# **Deadline 7 Submission on Behalf of the Neighbours and Users of Queen Elizabeth Park**

Interested Party reference no: **20022545**

© Crown copyright and database rights 2020 OS Licence Number AL100005237

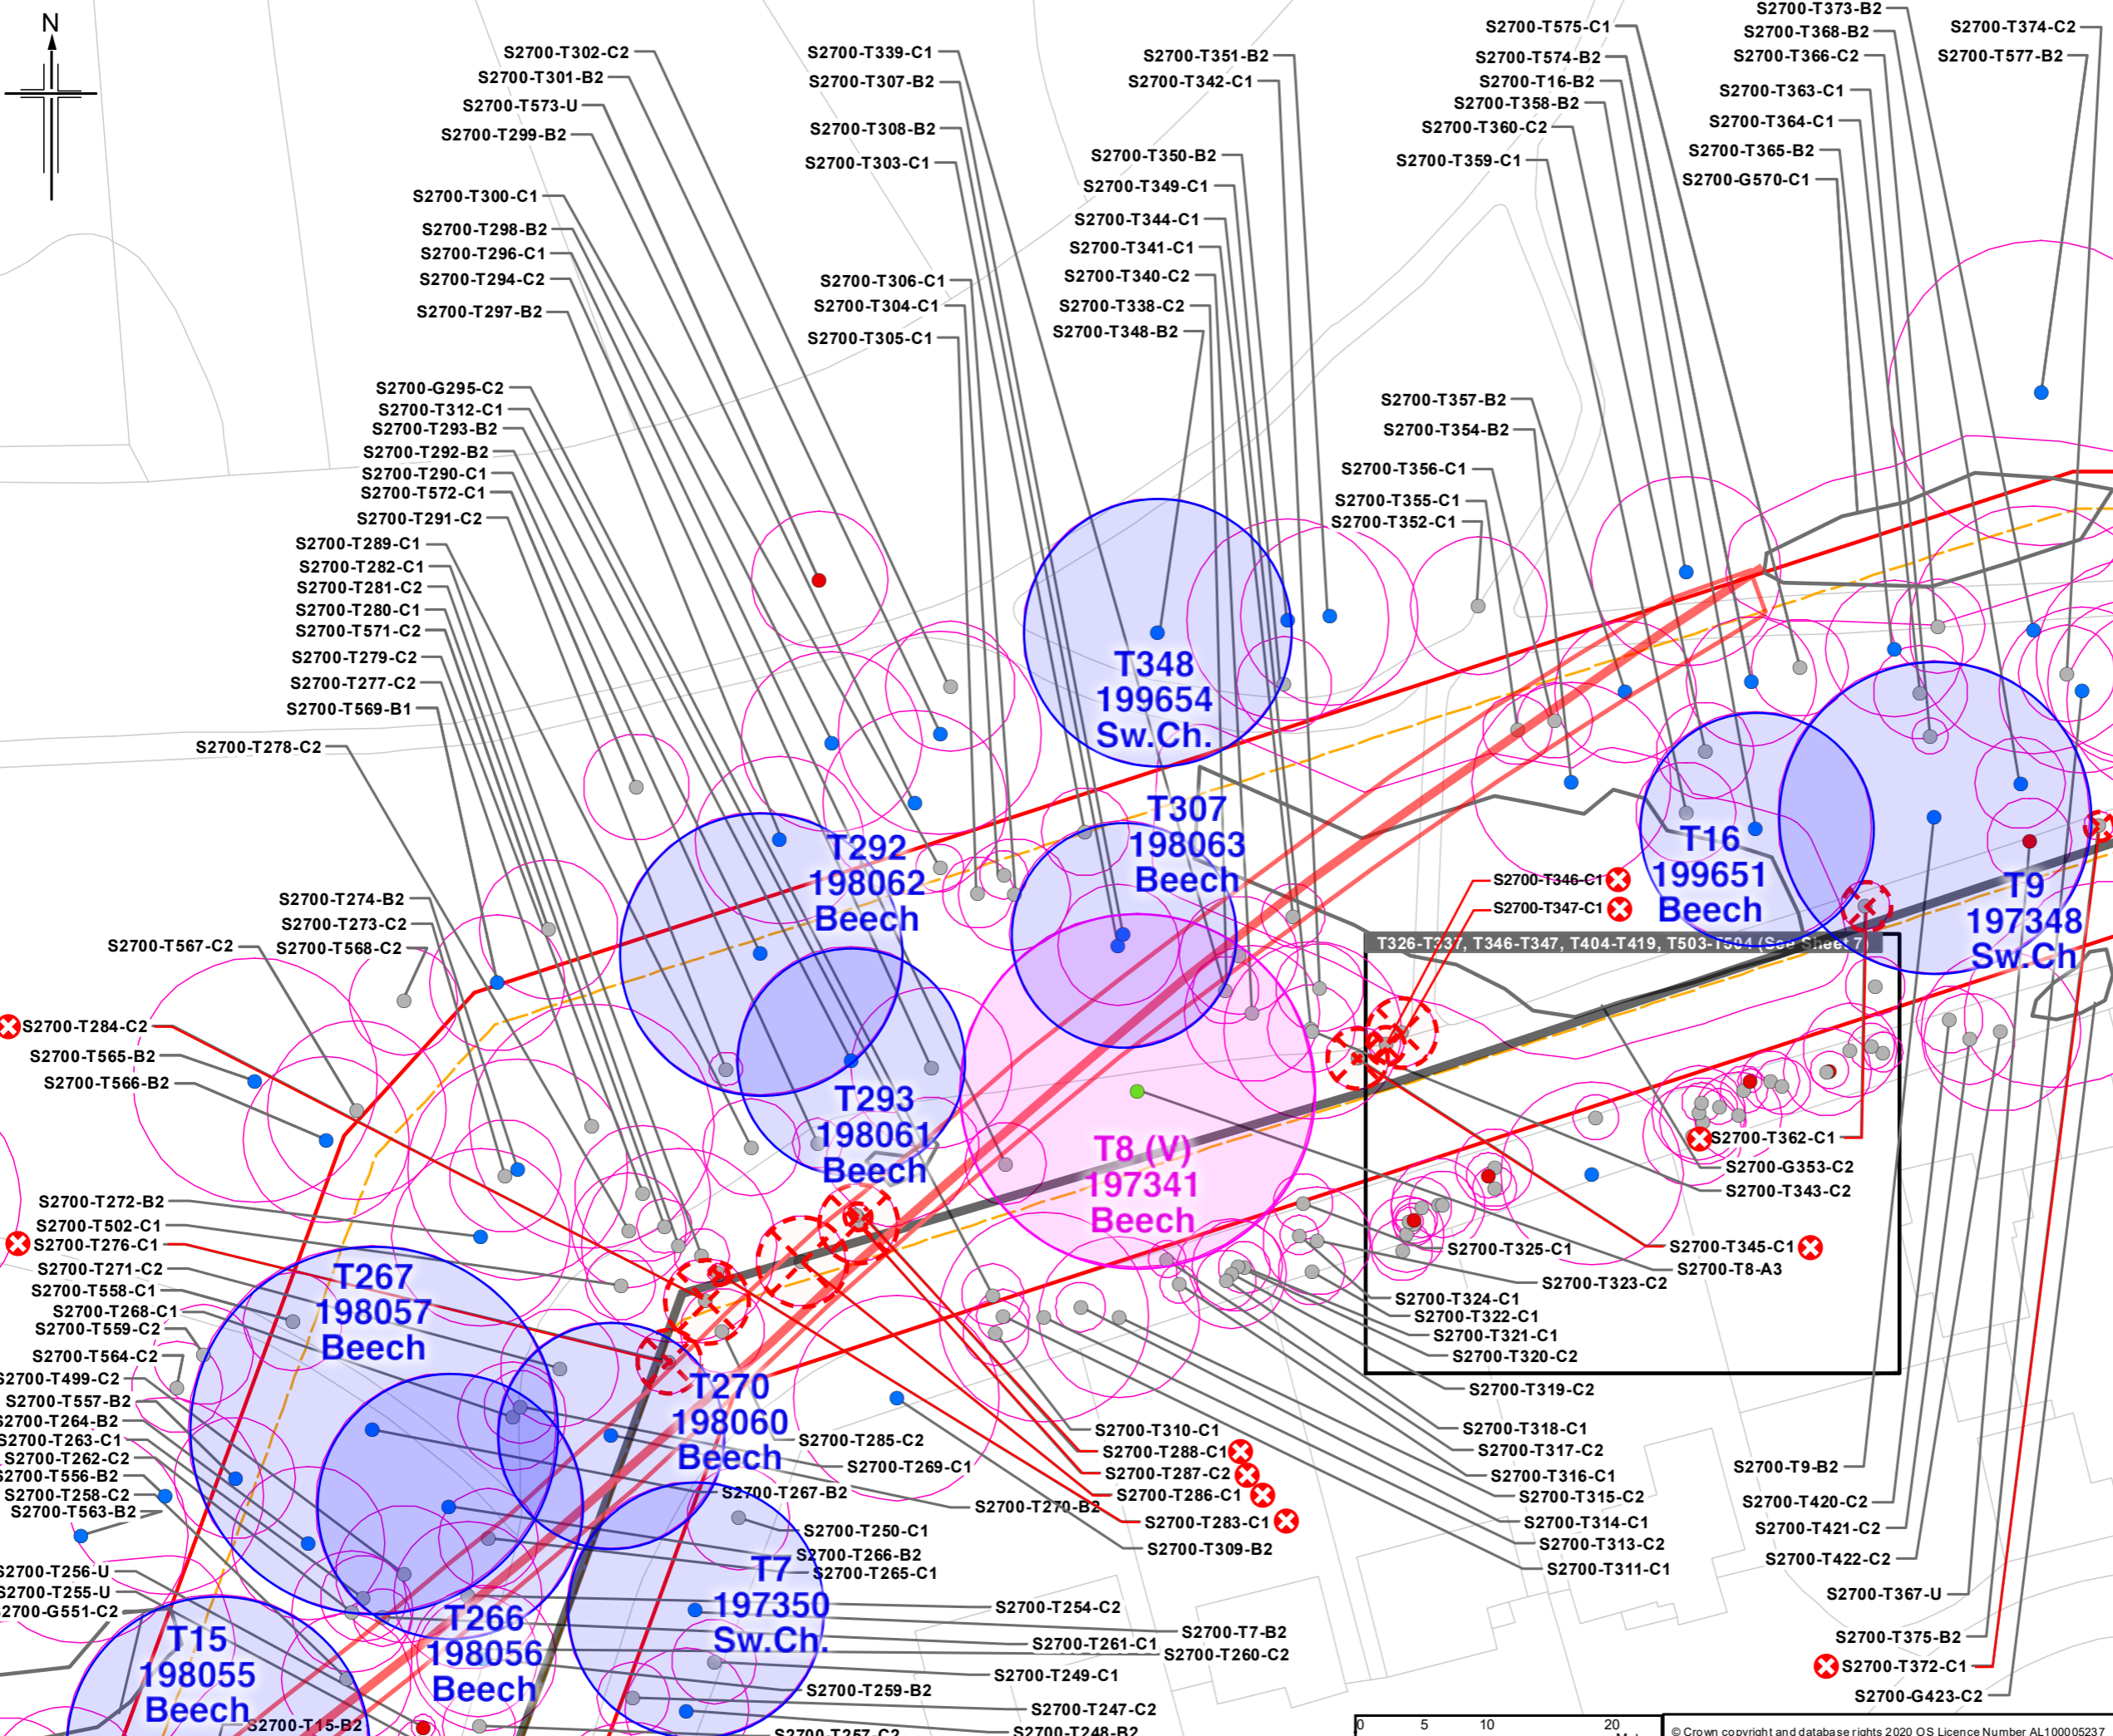
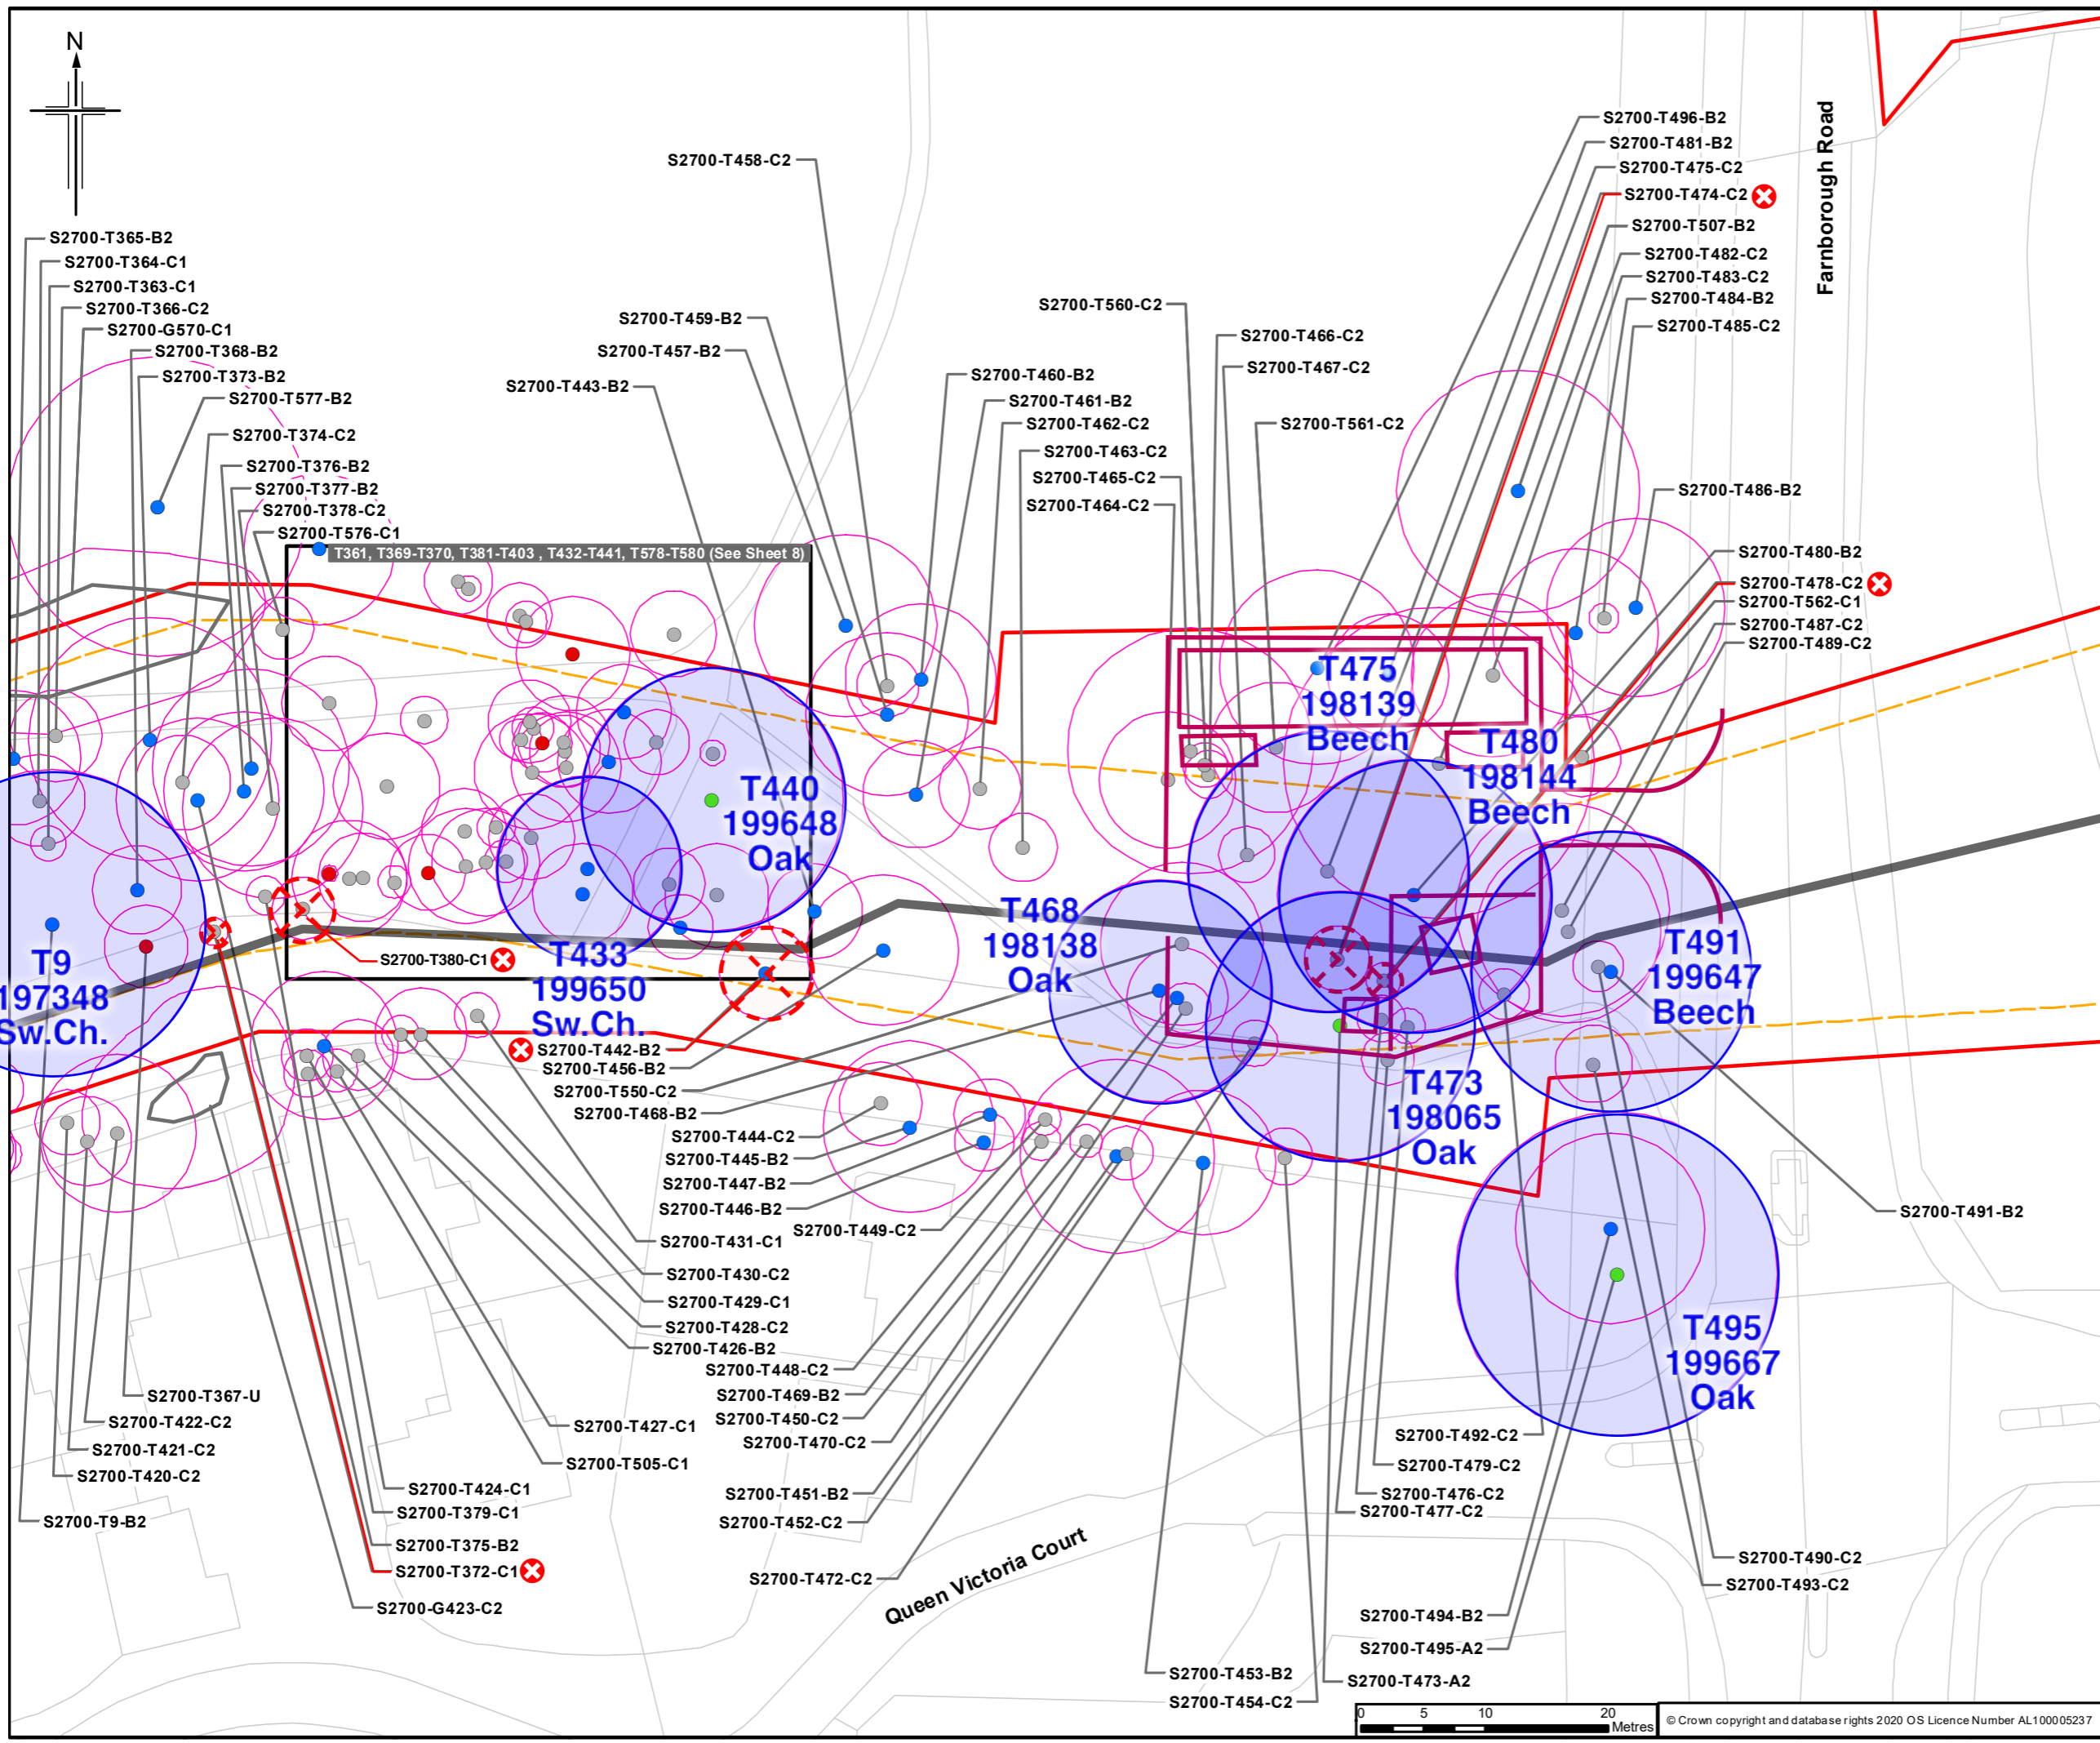
Corrected tree positions: T562 (sycamore), T487 (beech) and T489 (beech) are not correctly located on Esso's map. Dotted orange lines show the position on Esso's tree survey, solid orange lines show roughly where the trees actually are.

We also note that the drawings and tree survey in the SSP continue to feature the following errors:

1. Missing Notable Tree in the Cabrol Road compound area
2. Oak tree misclassified as sweet chestnut
3. Trees in the working area shown on the wrong side of the path
4. The 'pond' by the A325 is drawn in the wrong position
